Marine  
Management  
Organisation

MMO Reference: DCO/2022/00007  
Planning Inspectorate Reference: EN010125  
Identification Number: 20050160

**Planning Act 2008, RWE Renewables UK Dogger Bank South (West) Ltd and RWE Renewables UK Dogger Bank South (East) Ltd Proposed Dogger Bank South Offshore Wind Farms Order**

**Deadline 5 Summary**

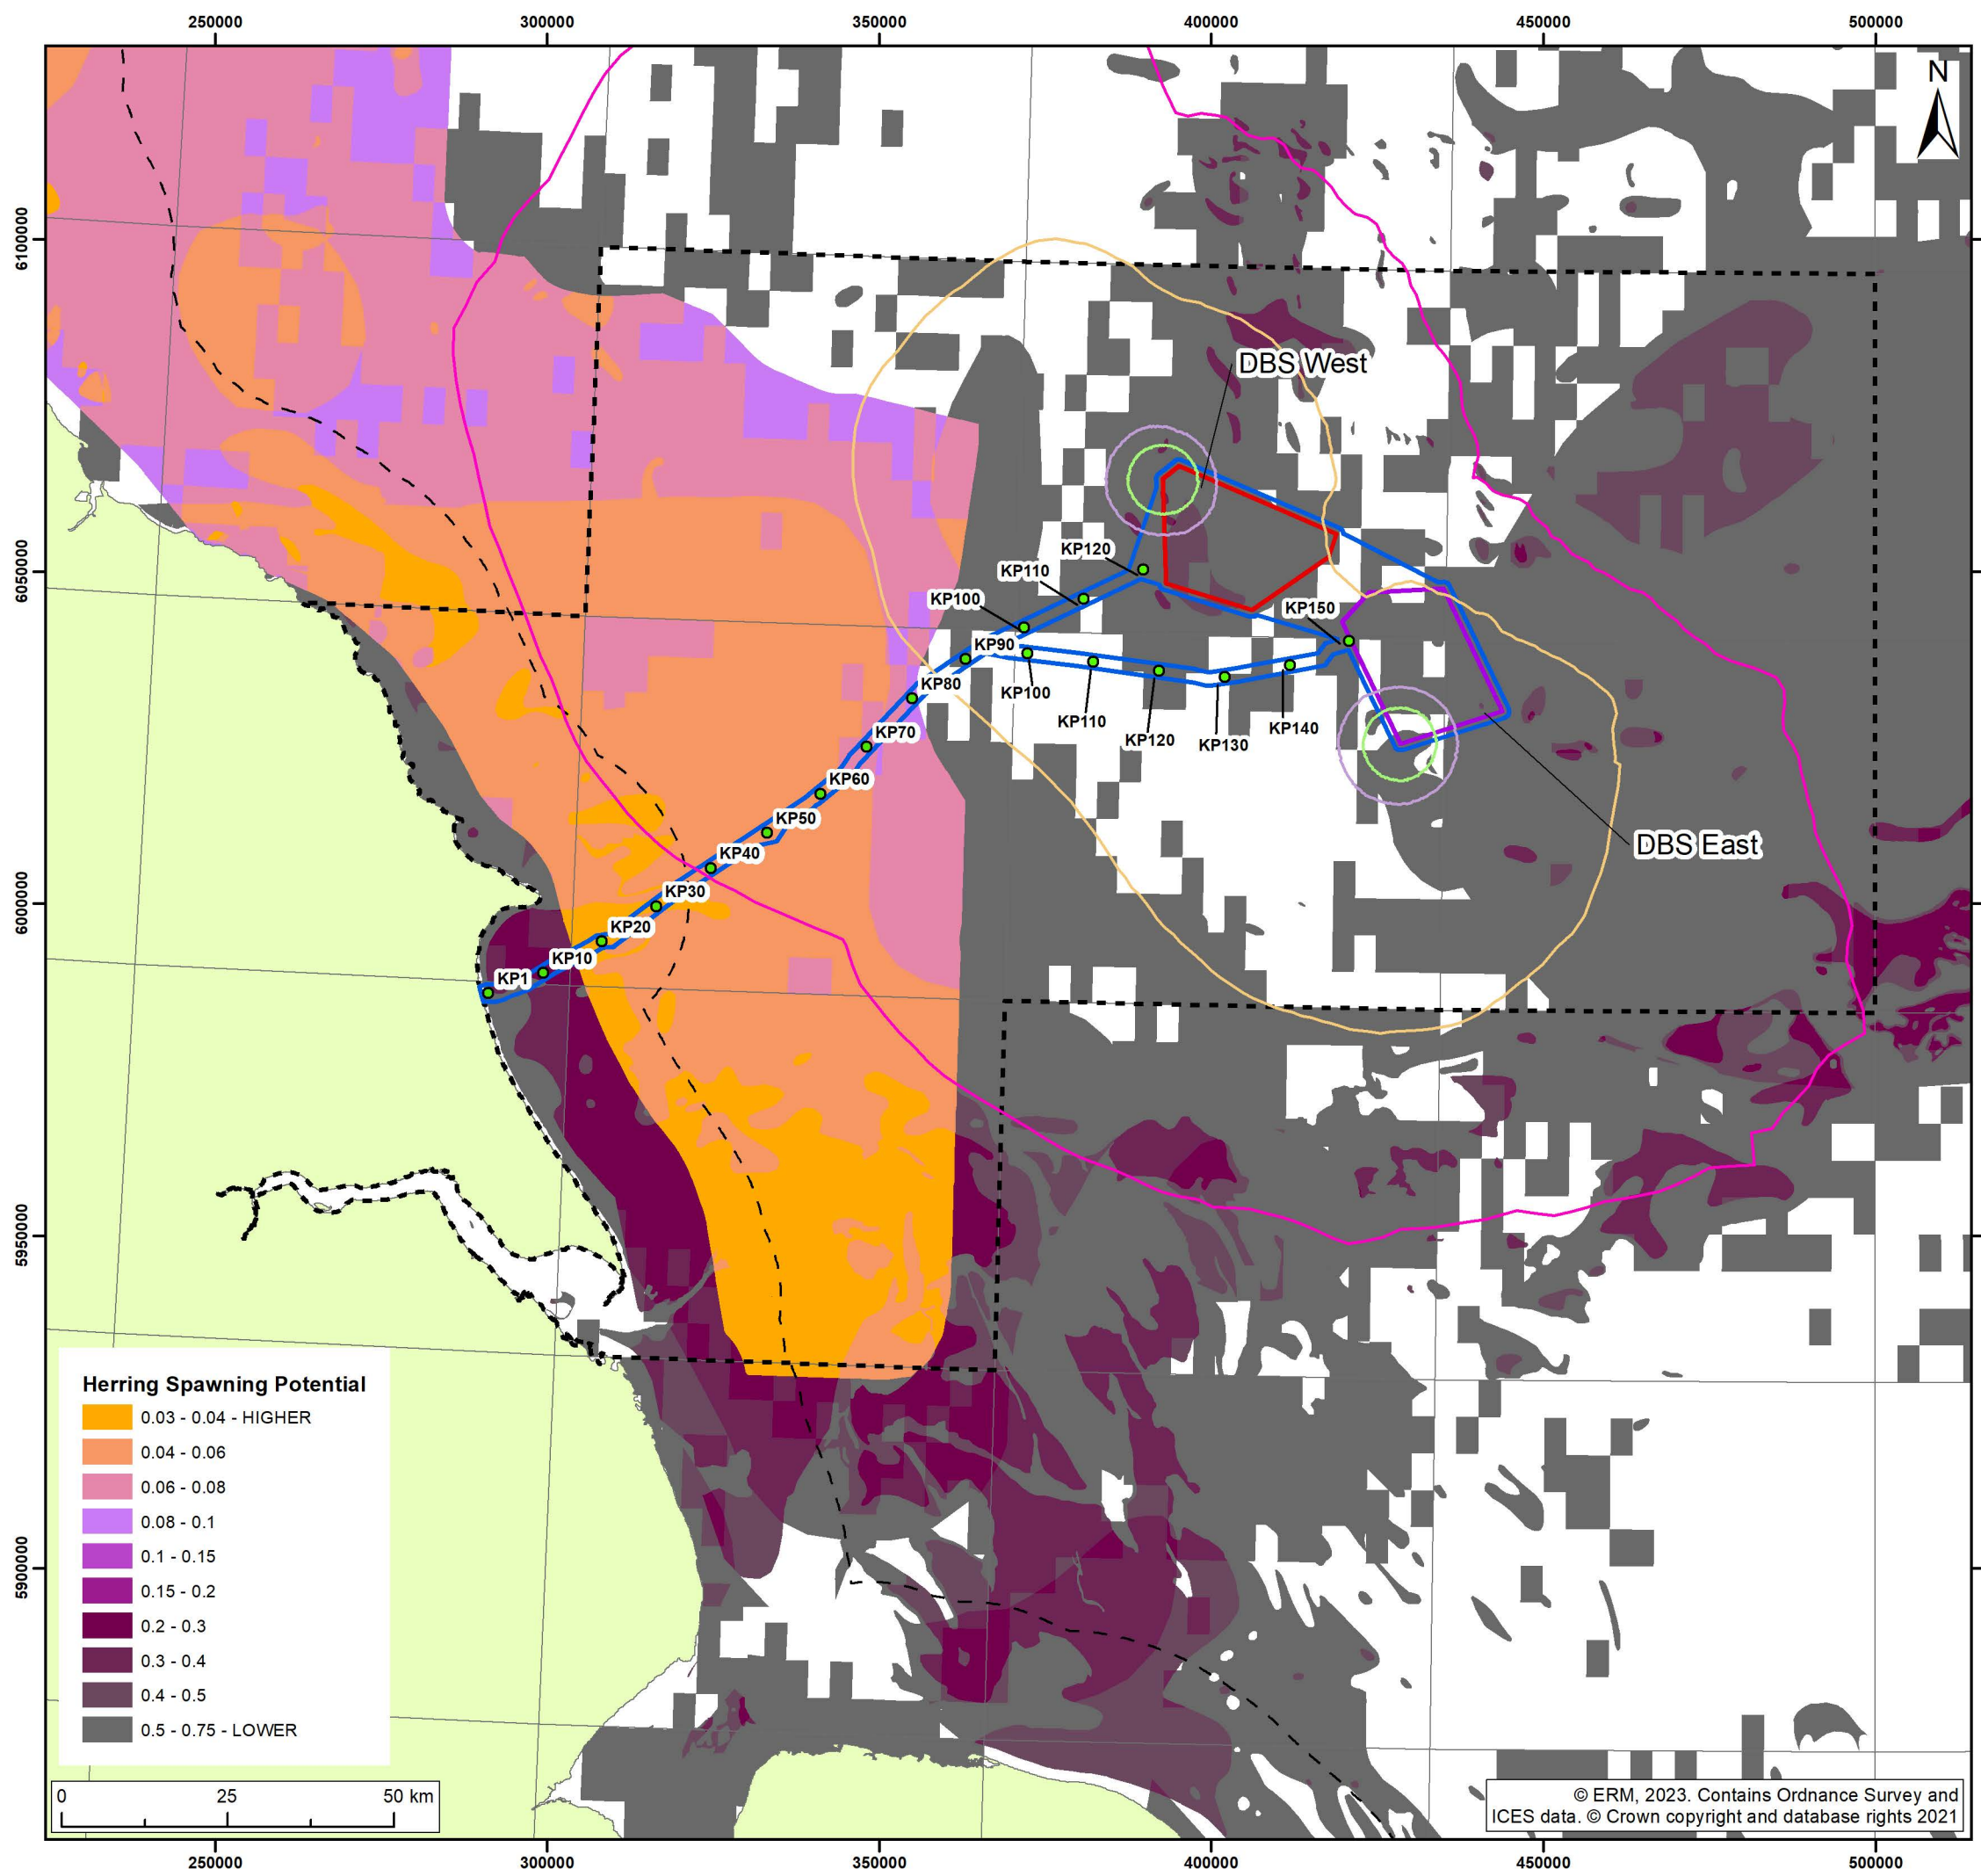
shown by Figure 2.7 of the Heat Mapping Report: Atlantic Herring and Sandeel, the MMO advised previously that the presentation of this figure should be amended so that the data can be more clearly interpreted.

Figure: 2-2	Drawing No: PB2340-MAR-OF-ZZ-DR-Z-0013	
Co-ordinate system: WGS 1984 UTM Zone 31N	Page Size: A3	Scale: 1:950,000
Project: Dogger Bank South Offshore Wind Farms	Report: Heat Mapping Report: Atlantic Herring and Sandeel

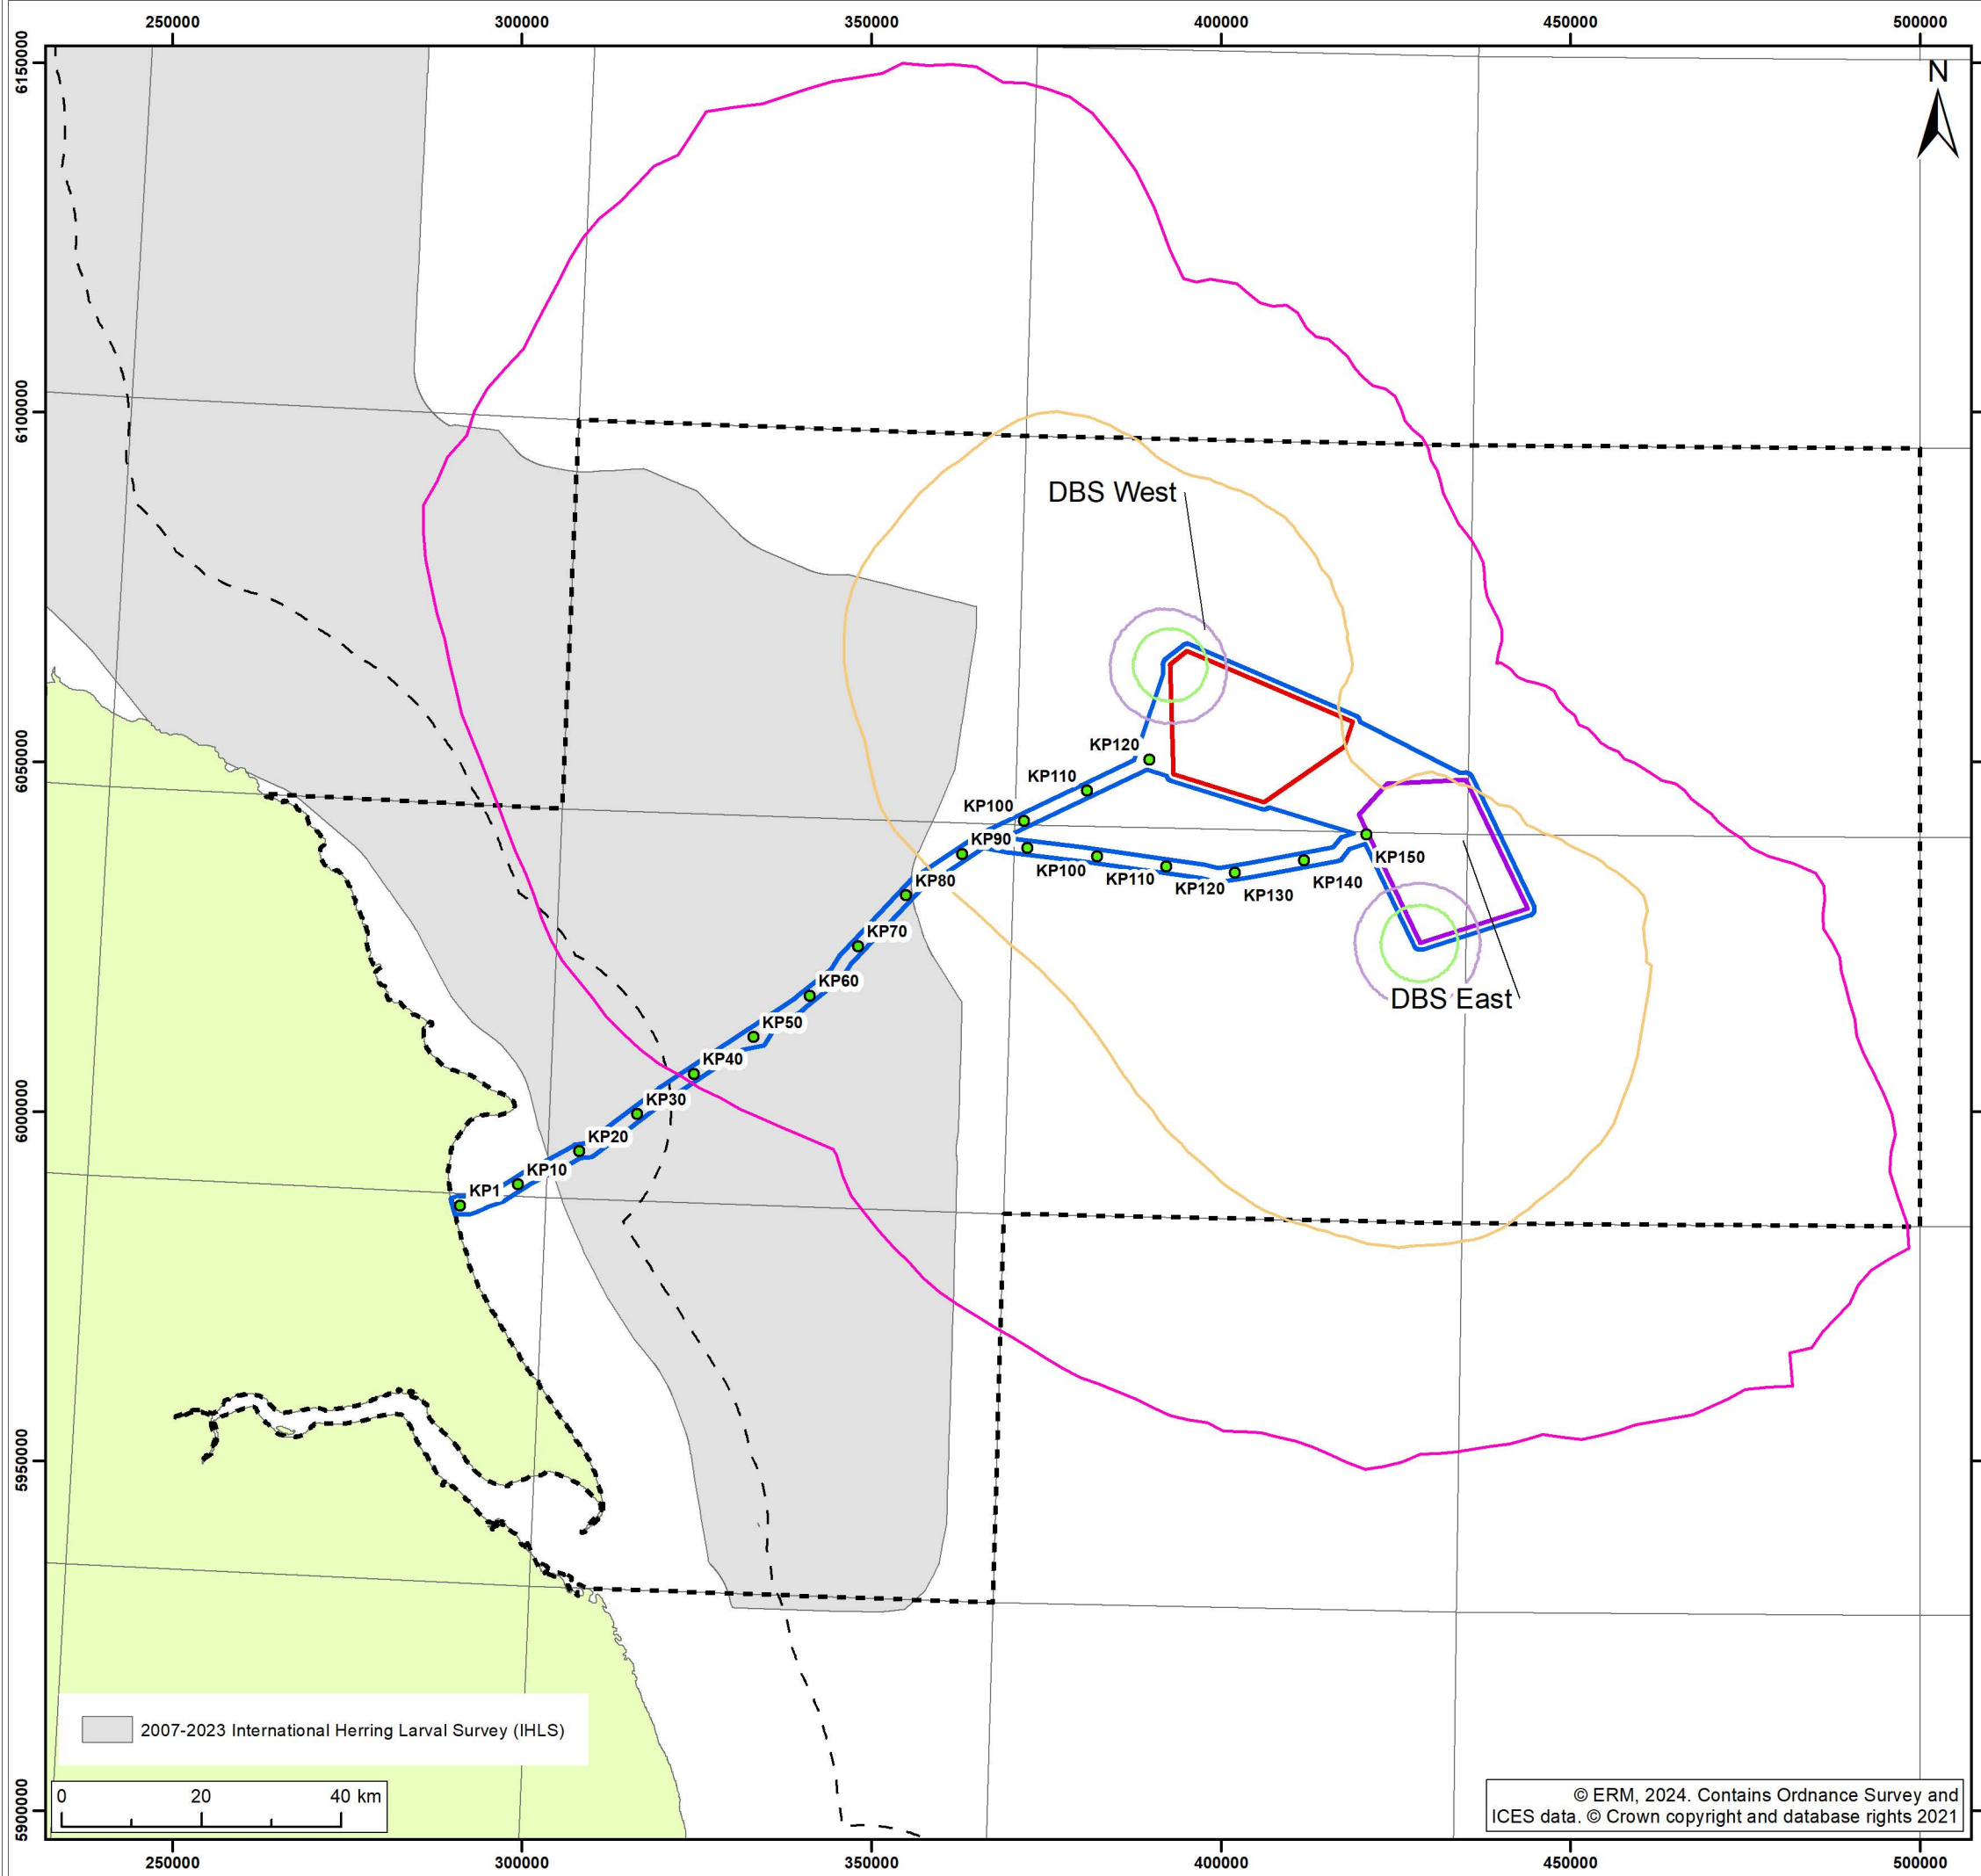
4.3.1 The MMO would like to refer the applicants to point 1.7.8 for further details on figures 1-2 and 2-2.
